Development Control  
Ribble Valley Borough Council

**Re:** Planning Application 18/0975

**Address:** Land east of Chipping Lane Longridge

**Description:** Application for the detailed approval of appearance, landscaping , layout and scale for the erection of 184 dwellings, made up from 55 affordable dwellings and 129 open market dwellings, including provision for the elderly (Phases 2 and 3) pursuant to outline consent 3/2014/0764, alongside associated open space, landscaping and access.

PHASE 2 / 3
 PLANNING LAYOUT

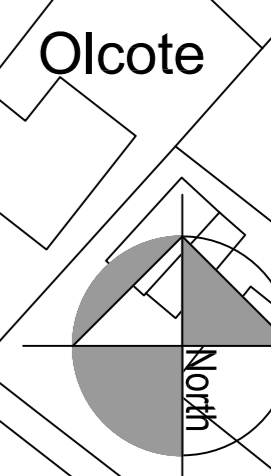
- There are a number of parallel but detached footpath-cycleways these should be attached to the adjacent to the carriageway at plots 17 - 71, 71-75, 53-56, 134-151 and 178 – 151.
- The 7 access ways to plots 182-173, 77-86, 91-107, 111-126, 134-151, 98-103 and 71-75 should only be through routes to non-vehicular traffic and should be terminated with a turning head of some description suitable for expected traffic.
- The turning heads at plots 98 and 103 require a longer return.
- A junction table to be provided at plot 35.
- Whilst not all have been measured, car parking spaces should be a minimum of 2.4m x5m where the access is used for vehicle and pedestrian access an additional 0.8m should be provided, plots 61-62 appear to have a pedestrian access omitted ( this is an example rather than a complete list of omissions),

- Garages whether internal or detached should have internal measurements of 3m x 6m driveways in front of garages should be 0.5m greater in length to allow the doors to open.
